Final Report - Corrections Required **Application No. ZONE-25-0021**

July 9, 2025

County File: OAR2512

City of Colorado Springs Project: ZONE-25-0021 - BLR Village C - MX-M Rezone

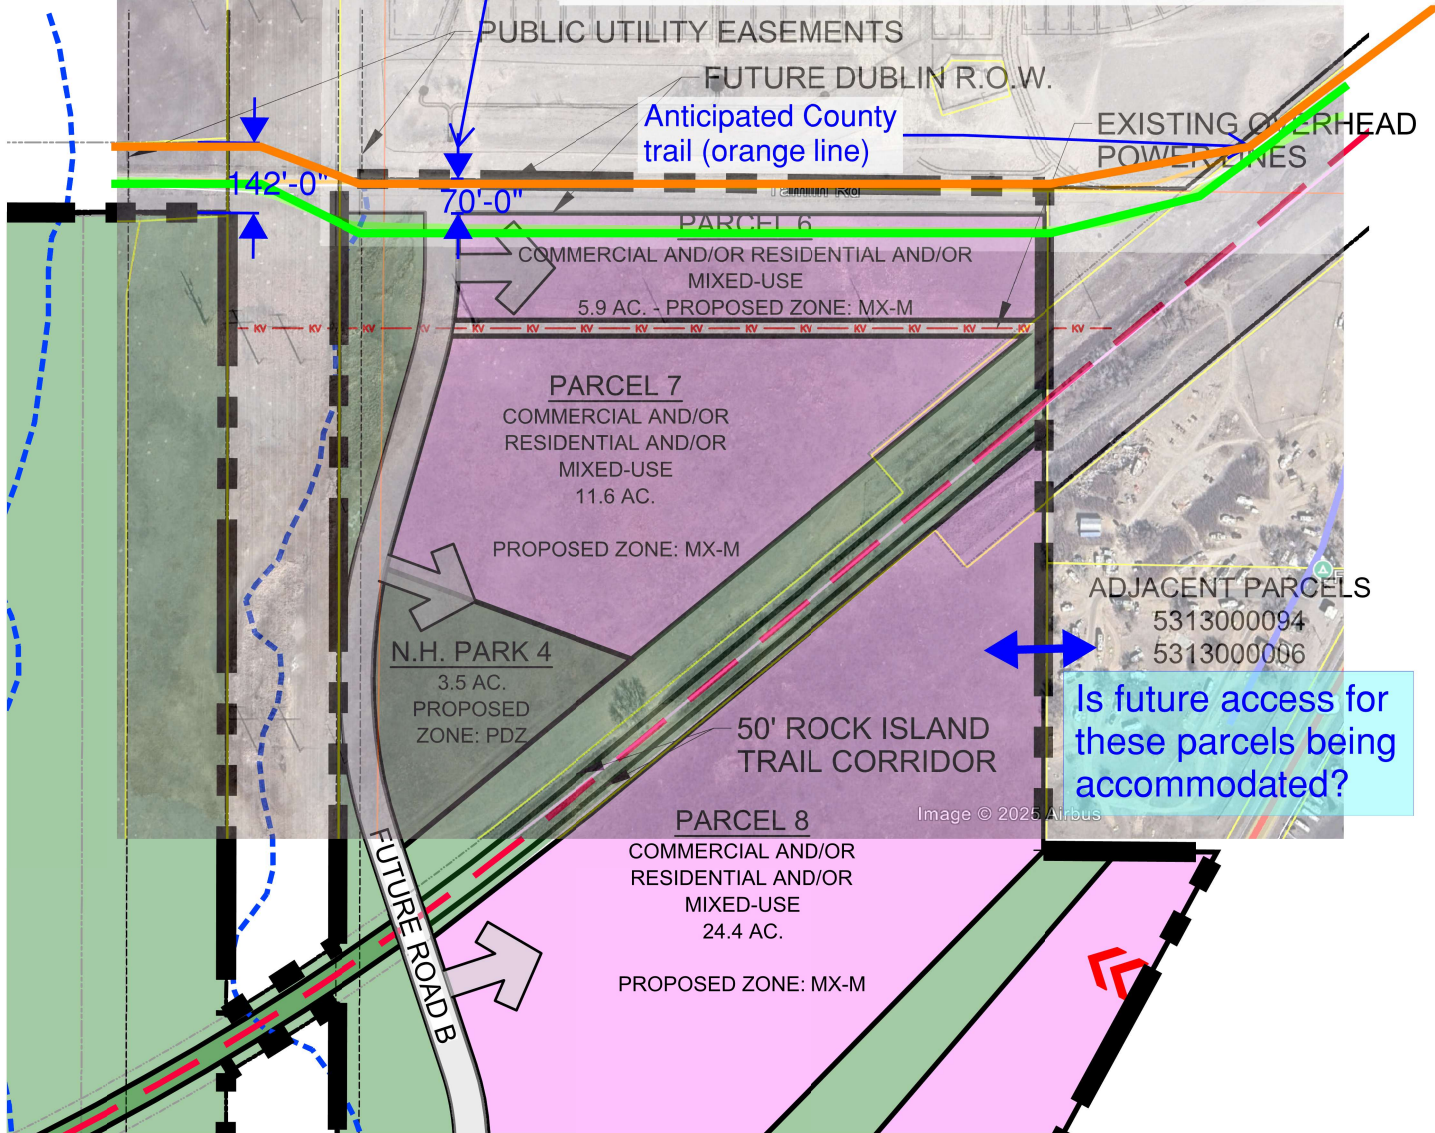
1. Note: Coordination is needed between the developer, the City and EPC (DPW and Parks) regarding the Dublin Blvd./Falcon Highway alignment. See attached sketch/redlines.
